Traffic Access Report

Re: Catherine McAuley Catholic College, Medowie NSW

For: Catholic Schools Office Diocese of Maitland-Newcastle

Project Number: 2544

Figure 19 | Car parking layout and bike parking spaces map (source: RtS 2019)

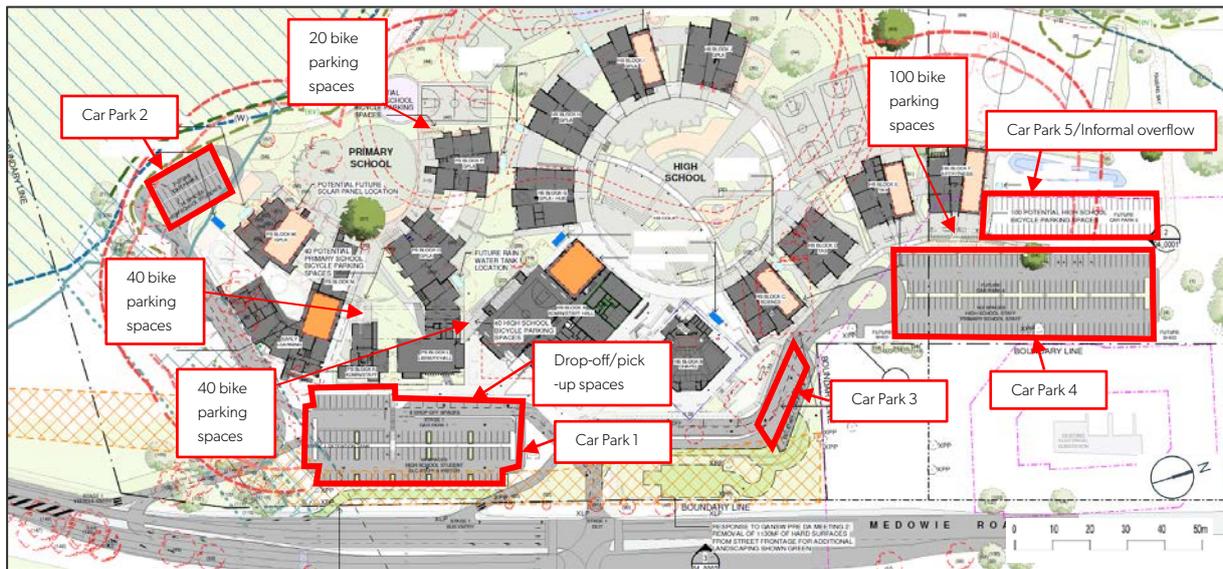
| <p>1.1 BCA Table D3.5 prescribes accessible car parking at a rate of one accessible space for every 100 car parks or part thereof for Class 9b schools. However, the Port Stephens Council Development Control Plan is more onerous, prescribing one accessible space for every 20 car parks.</p> | <p><i>BCA Table D3.5</i></p> |

Plans show that 269 car parking spaces will be provided, including parks designated as drop-off and loading zones. Therefore, the BCA requires three accessible car parking spaces to be provided, while the DCP requires 14 access car parking spaces. Six shared spaces are nominated in different car parking areas, indicating up to 12 accessible car parking spaces. The bus area additionally nominates accessible car parking and it is understood that this will be a shared arrangement, to offer the total number of accessible spaces required by the DCP.

The accessible car parking spaces are to comply with AS 2890.6 including the following features:	<i>BCA D3.5 Table D3.5</i>
--	----------------------------

| <p>a) A firm plane surface with a maximum cross fall of 1:40 (1:33 if of a bitumen surface and outdoors) for the accessible car parks and associated shared areas.</p> | <i>AS 2890.6 2.3</i> | Confirm for CC |
| <p>b) Minimum dimensions of 2400mm wide x 5400mm long for the angled accessible car parks.</p> | <i>AS 2890.6 2.2.1 a</i> | Confirm for CC |
| <p>c) A shared area adjacent to the angled accessible car parks with minimum dimensions of 2400mm wide x 5400mm long and a bollard located in accordance with AS 2890.6. (Note that this shared area may be a common shared area between two accessible car parking spaces.)</p> | <i>AS 2890.6 2.2.1 b e Fig. 2.2, 2.3</i> | Confirm for CC |
| <p>d) A shared area is also required at one end of the angled accessible car parks with minimum dimensions of 2400mm x 2400mm. This may be located within a trafficked area and is not required to be line marked.</p> | <i>AS 2890.6 2.2.1 c Fig. 2.2, 2.3</i> | Confirm for CC |
| <p>e) Parallel accessible car parks (ie shared with the bus area) require minimum dimensions of 3200mm wide x 7800mm long.</p> | <i>AS 2890.6 2.2.2 a</i> | Confirm for CC |

Access elements	Reference	Assessment
f) A shared area adjacent to the parallel accessible car parks with minimum dimensions fo 1600mm wide x 7800mm long (this may be at a higher level than the car park being separated by a kerb with a maximum height of 190mm and having additional space to provide a kerb ramp complying with AS 1428.1).	AS 2890.6 2.2.2 b Fig. 2.4, 2.5 Fig. 2.6	Confirm for CC

g) Minimum headroom of 2500mm is required above the accessible car parks and the associated shared areas. The vehicular path of travel to the accessible spaces is to have minimum vertical clearance of 2200mm.	AS 2890.6 2.4 Fig. 2.7	Confirm for CC

h) Signage is required to designate accessible car parking spaces for the use of people with a disability. The international symbol of access (white symbol on blue background) is to be placed as a pavement marking in accordance with AS 2890.6.	BCA D3.5 d AS 2890.6 3.1	Confirm for CC

i) Yellow, slip-resistant pavement markings are to identify dedicated parking spaces and shared areas. Shared areas are to be marked with diagonal lines complying with AS 2890.6.	AS 2890.6 3.2 3.2 b ii	Confirm for CC
